DECISION DELEGATED TO HEAD OF PLANNING

Application No: H16-0505-25 **Applicant:** Mr R Campanaro

Proposal: Details of existing & proposed site & floor levels & foul & surface water disposal (Conditions 4 & 5 of H16-0330-20)

Location: Tidswell Bungalow Burr Lane Spalding

SITE PLAN 1:250

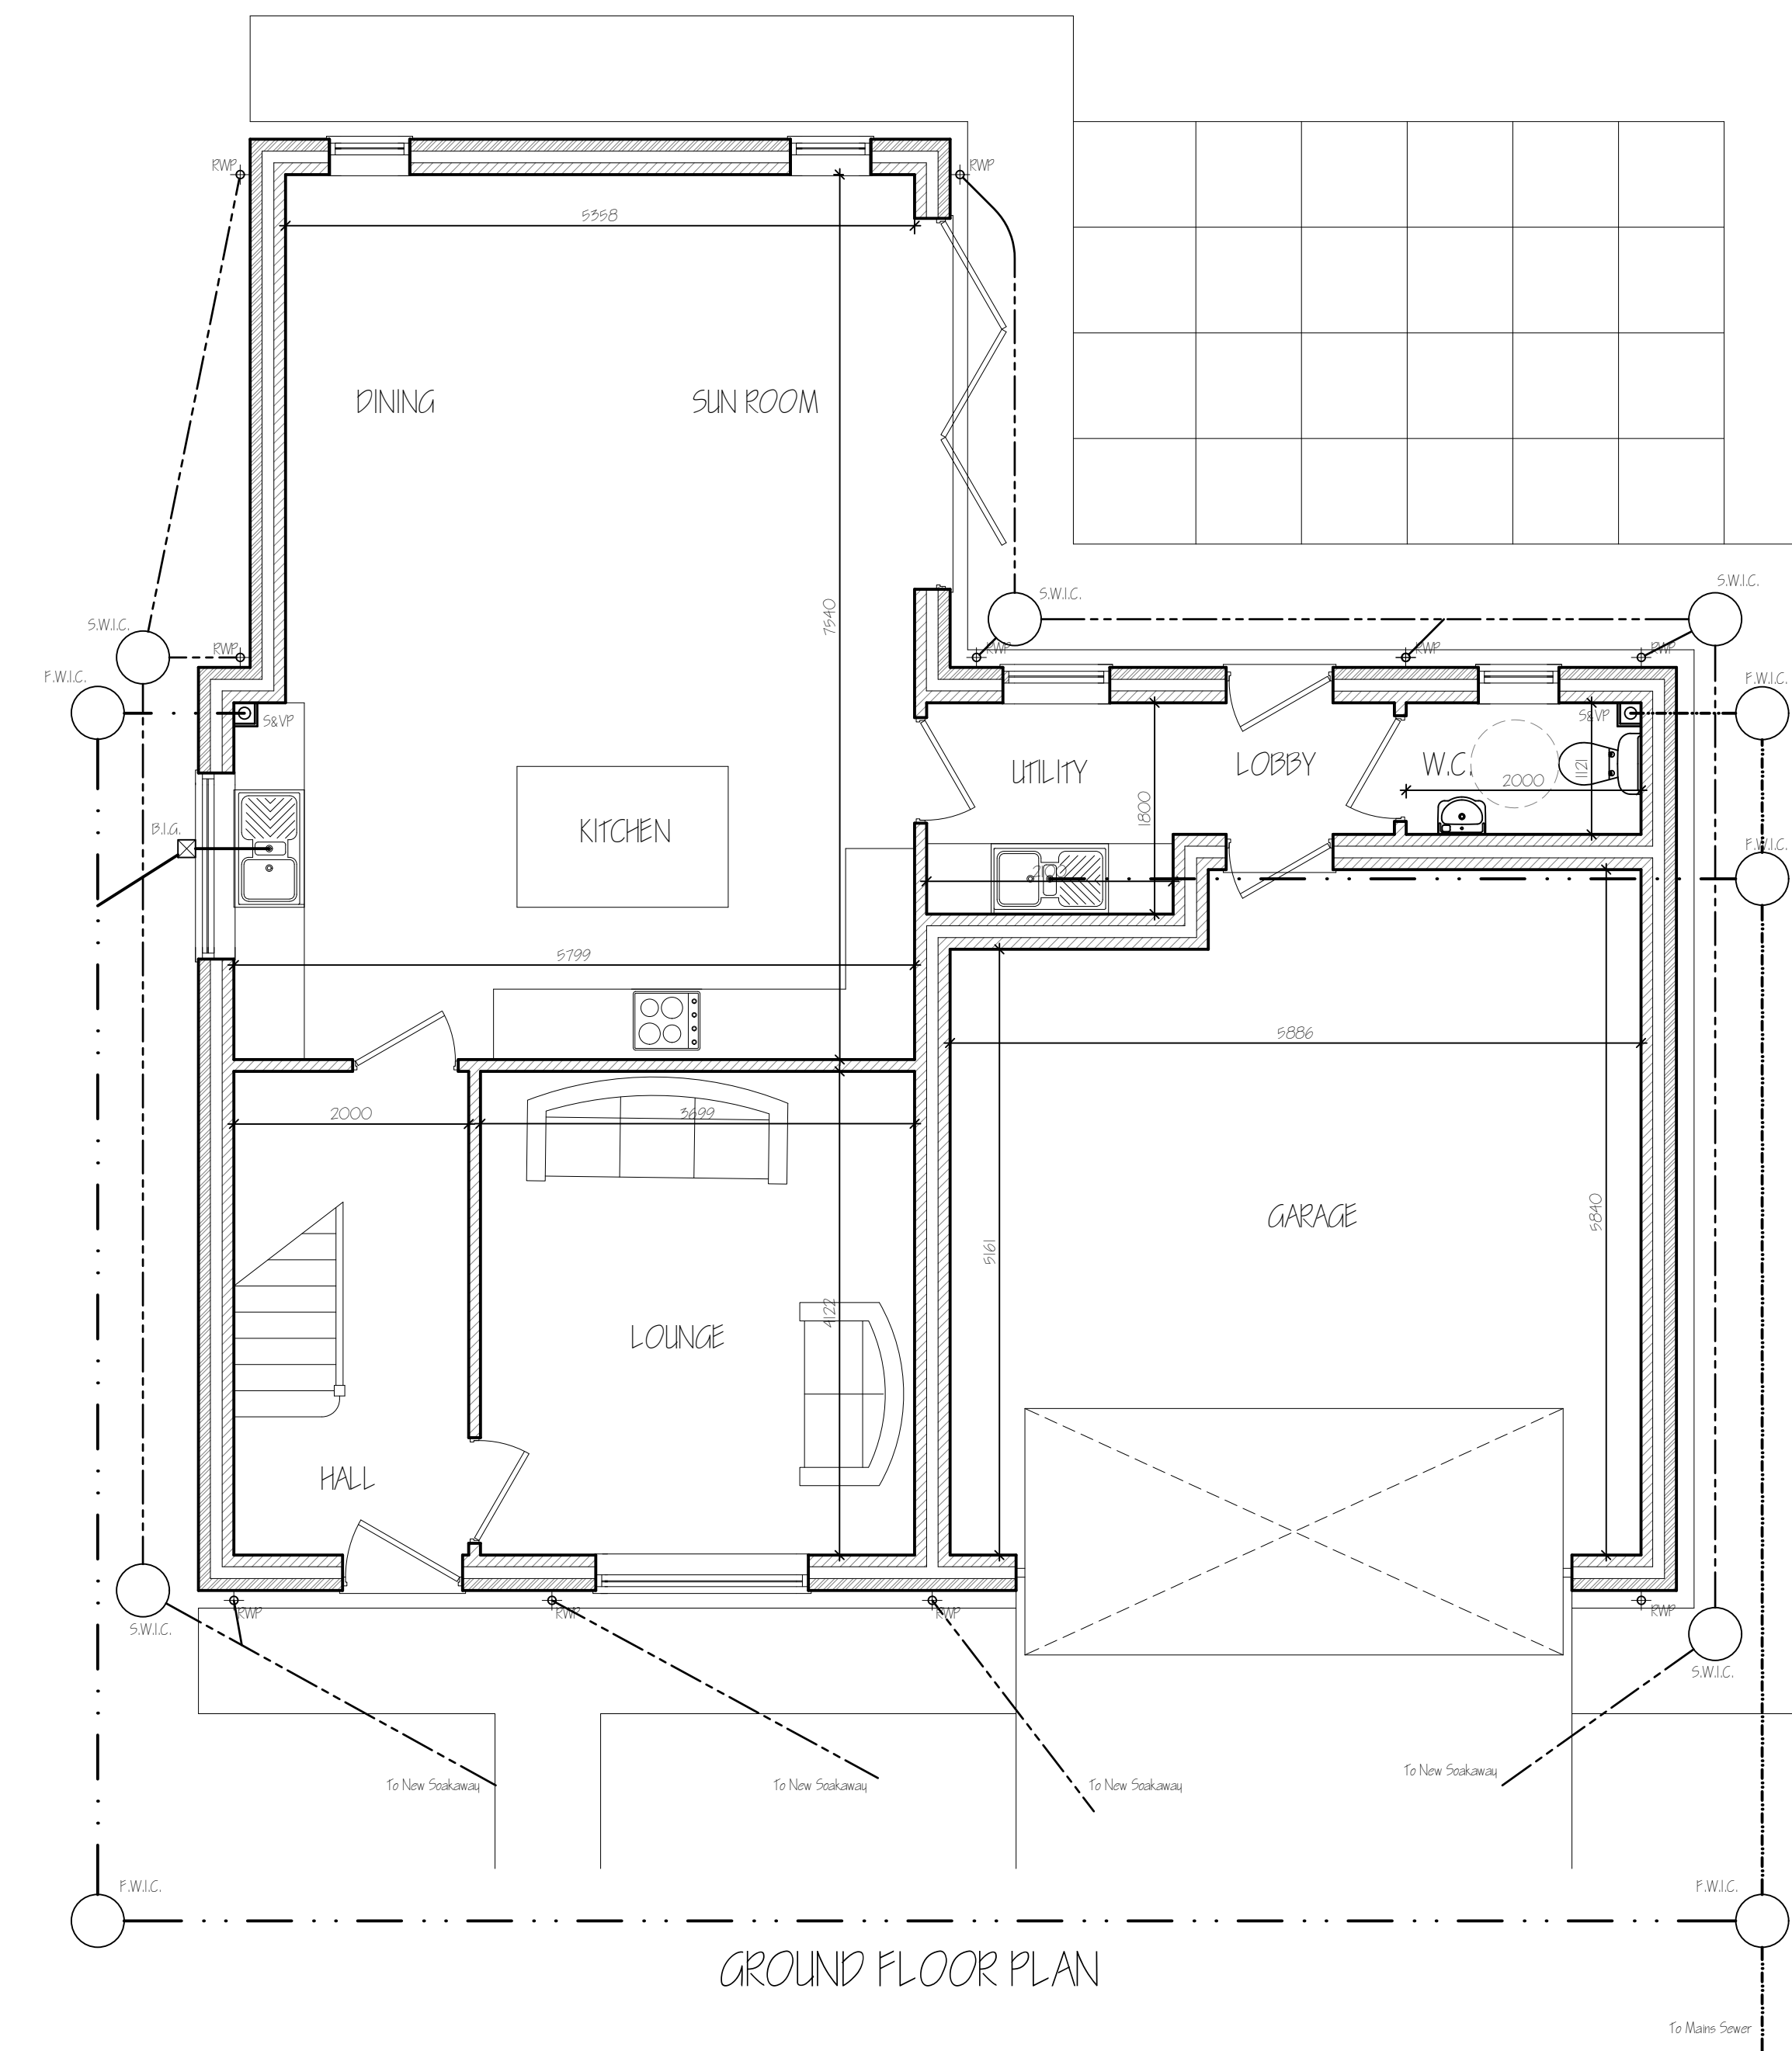
The proposal shows a finished floor level of 10.3m, which is approximately 700mm higher than the lowest point of the site and 300mm higher than existing site levels at the road. It should be noted here that the adjacent dwelling to the east has been raised by approximately 500mm.

The flood risk assessment submitted as part of H16-0330-20 required a minimum increase in finished floor level of 300mm. To this end, the proposed levels are considered acceptable and would ensure the dwelling safe from the impacts of flooding. The FFL is broadly consistent with neighbouring dwelling and is only 300mm above road level, thereby preventing a significant character impact emerging from the proposed site levels.

It is proposed that surface water would be drained via soakaways. While percolation tests to show the viability of this method have not been submitted, it is considered that proposed method would be broadly acceptable. The viability of soakaways in the immediate area has been established under the neighbouring scheme, and there is no evidence before the Council that infiltration is not acceptable here.

It is proposed that foul water is to be disposed of to a main sewers. Anglian Water are obliged to accept additional connections. Therefore, the proposed foul water drainage method is considered acceptable.
